**From:** Brian Banister [REDACTED]  
**Sent:** 21 September 2025 10:15  
**To:** Planning.Responses  
**Subject:** Arun Conservation Area Advisory Panel comments on applications

### **BN/97/25/PL - Land off Church Lane, Barnham**

PROJECT
Proposed Change of Use to 4no. Gypsy/Traveller
Plots on Land off Church Lane, Barnham
CLIENT
Mrs R Brazil
STATUS
PLANNING
DRAWING
SITE SECTIONS

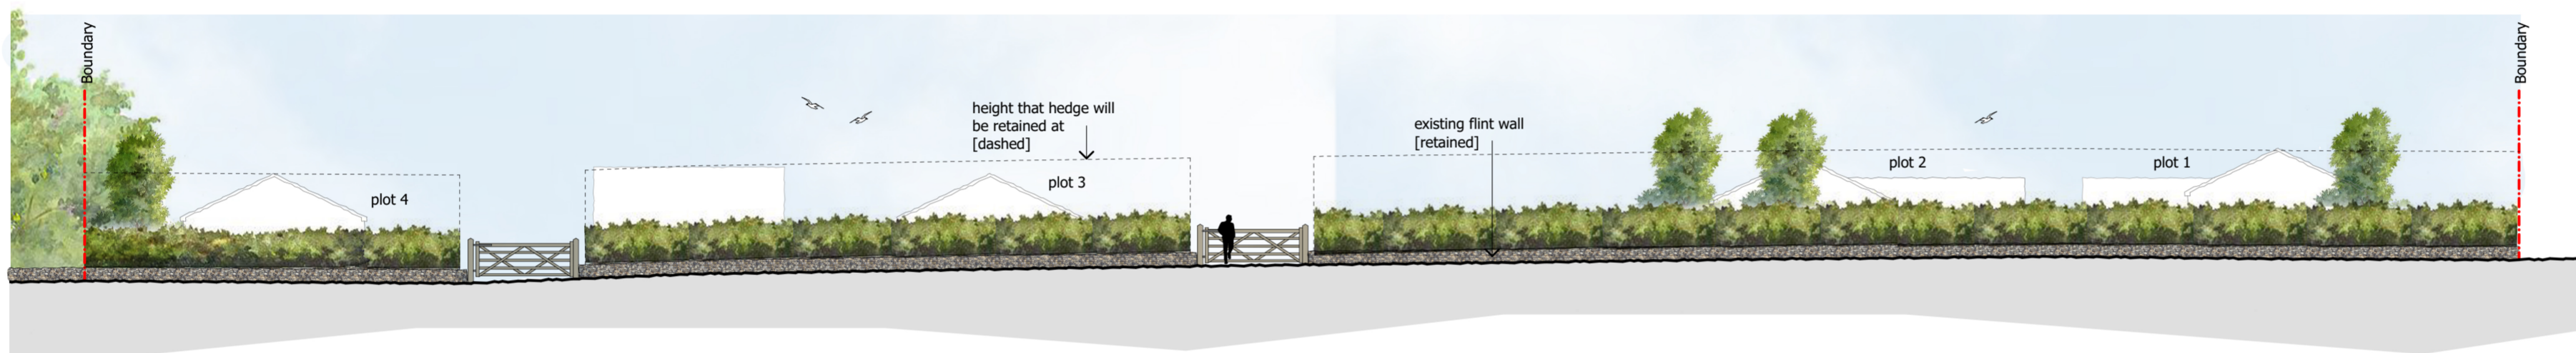
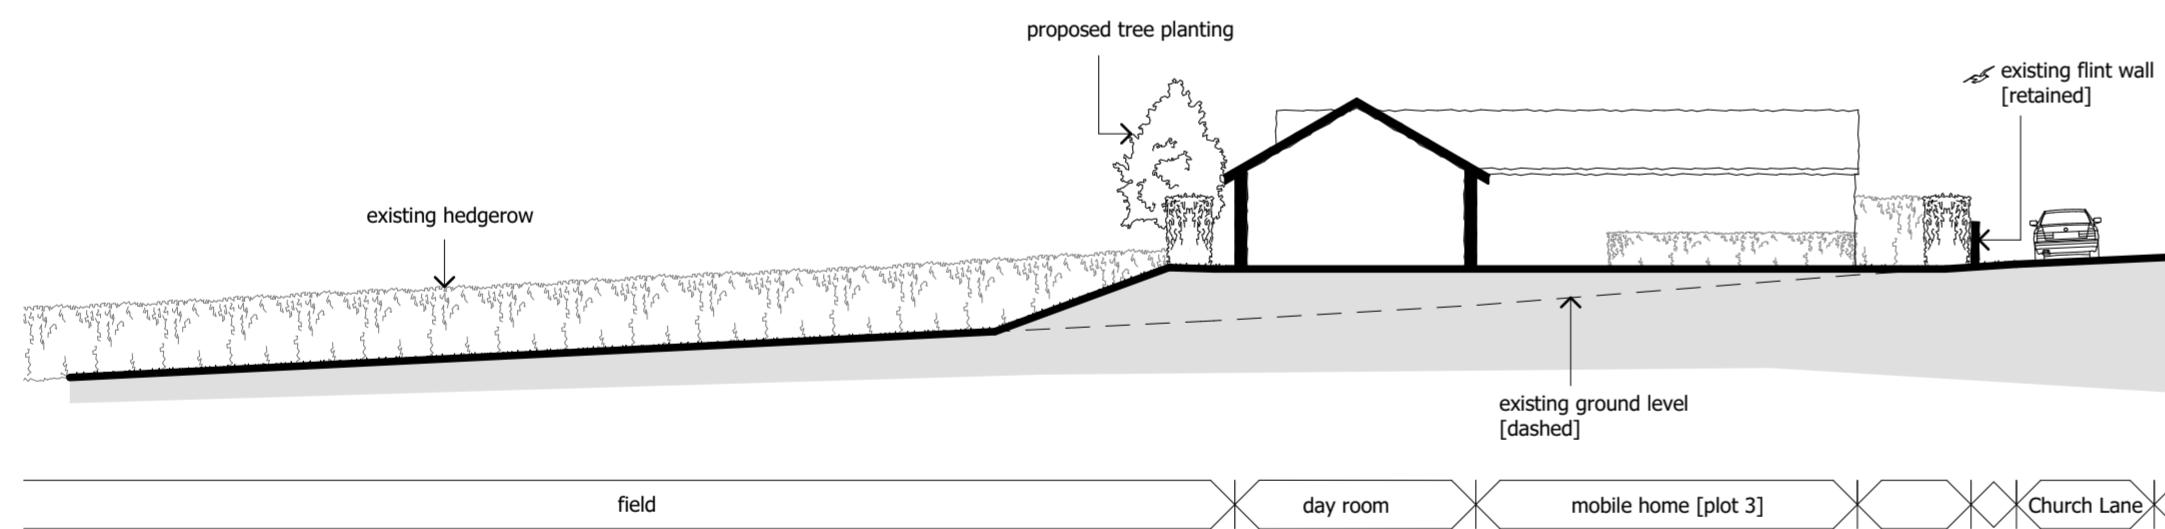
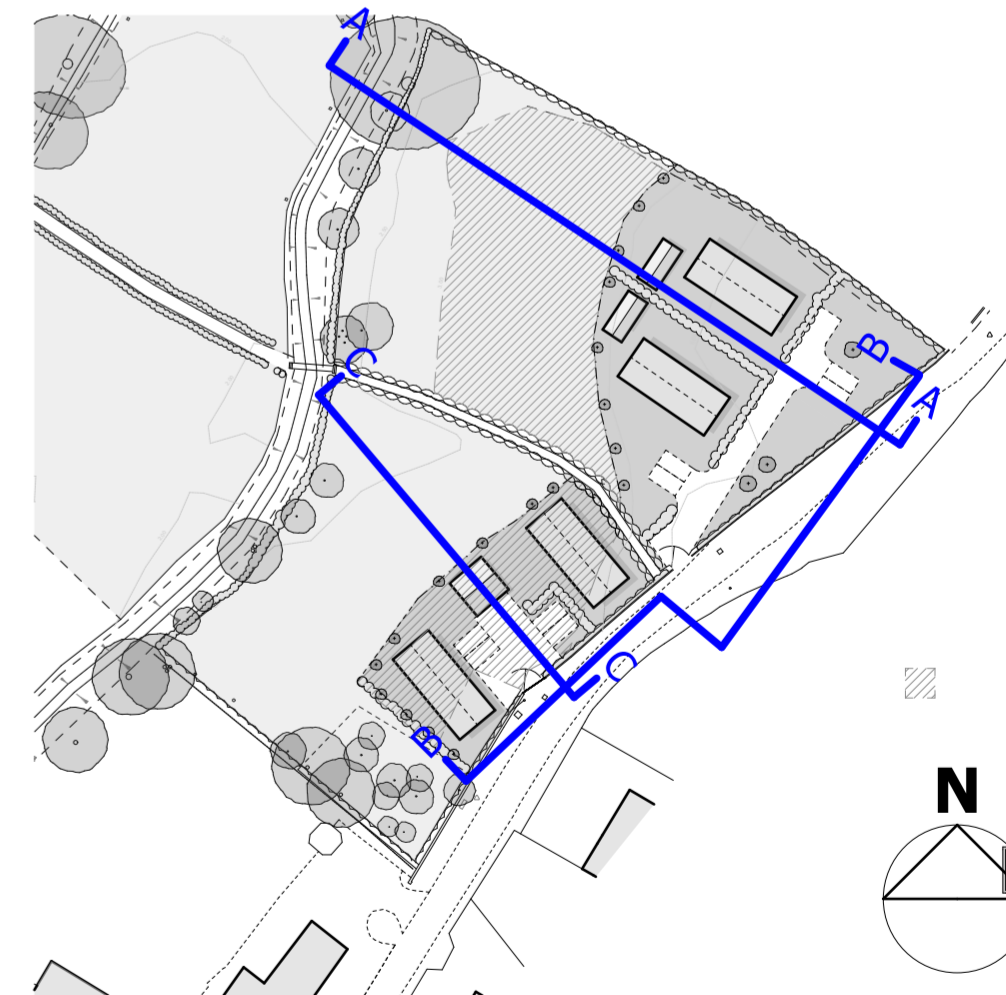
The introduction of structures, buildings, hardstandings, alterations to natural contours, etc will totally change the character of the site from rural to urban and will detract materially from the setting and heritage significance of the conservation area.

The Panel was also concerned that the turning circles required for vehicles entering and exiting the site could possibly necessitate the widening of the existing access points, leading to the loss of parts of the boundary flint walling which is an important feature of this essentially rural conservation area.
